CITY OF ALBUQUERQUE
Planning Department
January 25, 2006
DRB Comments

PROJECT # 1004652 APPLICATION # 05-00070

RE: Ceja Vista, Unit 1/sketch

DEVELOPMENT REVIEW BOARD--SPEED MEMO

SKETCH PLAT
 CEJA VISTA, UNIT 1

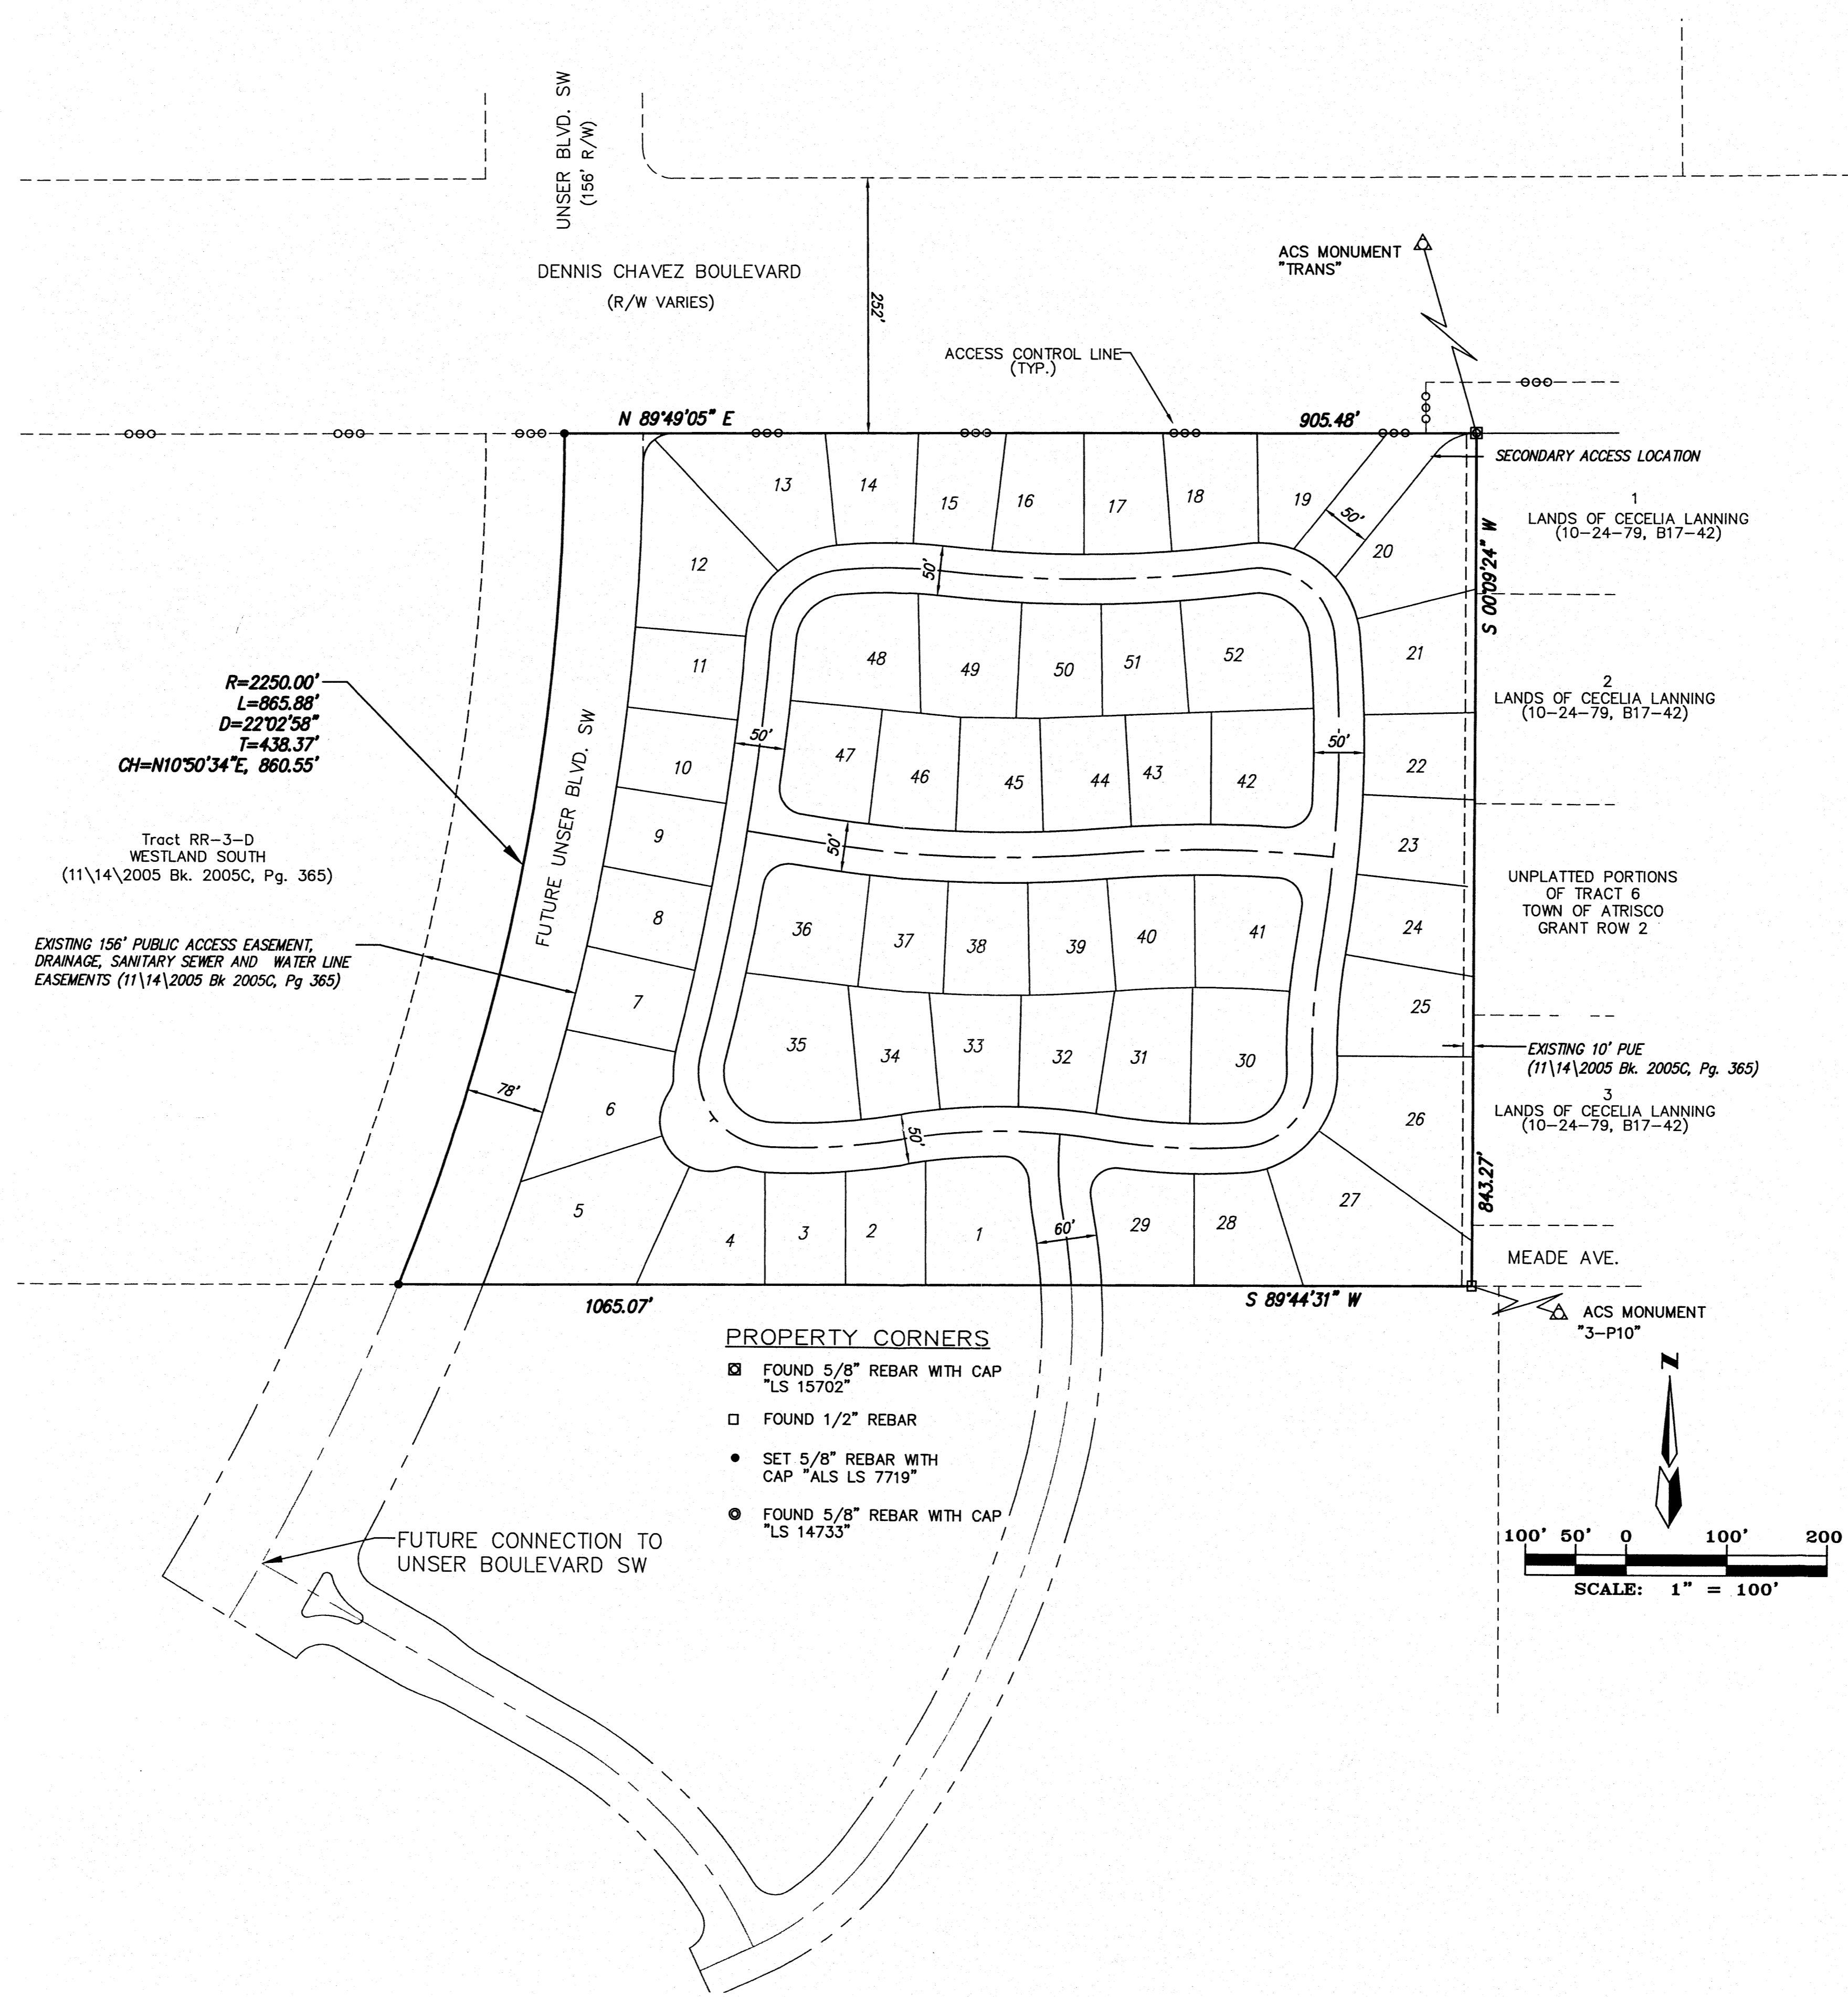
An approved Drainage Management Plan (DMP) for the entire basin is required for preliminary plat approval. AMAFCA's review and approval are required for Preliminary and/or Final Plat approval.

1. These three proposed minor-sketch plats should be examined together. They should inter-relate and should be planned together.
2. There is both insufficient vehicular and pedestrian access to Dennis Chavez Boulevard from the platted areas. Units 2 and 3 west of Unser line Dennis Chavez with about ½ mile of continuous rear yards. I see no breaks for pedestrians or vehicles. That would funnel vehicles from all of these units indirectly to Unser and then up to Dennis Chavez. This endless wall cuts off any possibility for pedestrian connections to future commercial services, parks and schools or bus service and once again creates a barren isolated space on the roadway. Dennis Chavez will be where the high school is located. The street and subdivision next to it should be designed so that kids can walk safely to the bus or school.

3. Unser is the principal neck of the traffic funnel... that is what it will become.
4. The park is poorly placed. It is too far to the west. It should be more centrally located. It would be difficult to walk there from most of the residential lots because of the circuitous street pattern and overly long street lengths.

Too many residential lots back up to the park. They should face the park to provide direct access and surveillance. The park should be treated like a public amenity rather than an afterthought.

If the park were to remain in the same spot, then lot 44 of unit 2 and lot 41 of unit 3 should be removed or moved to provide direct park access from these two disconnected subdivisions.

5. All three units or sketch plats have poor interior and interconnecting pedestrian and vehicular access.
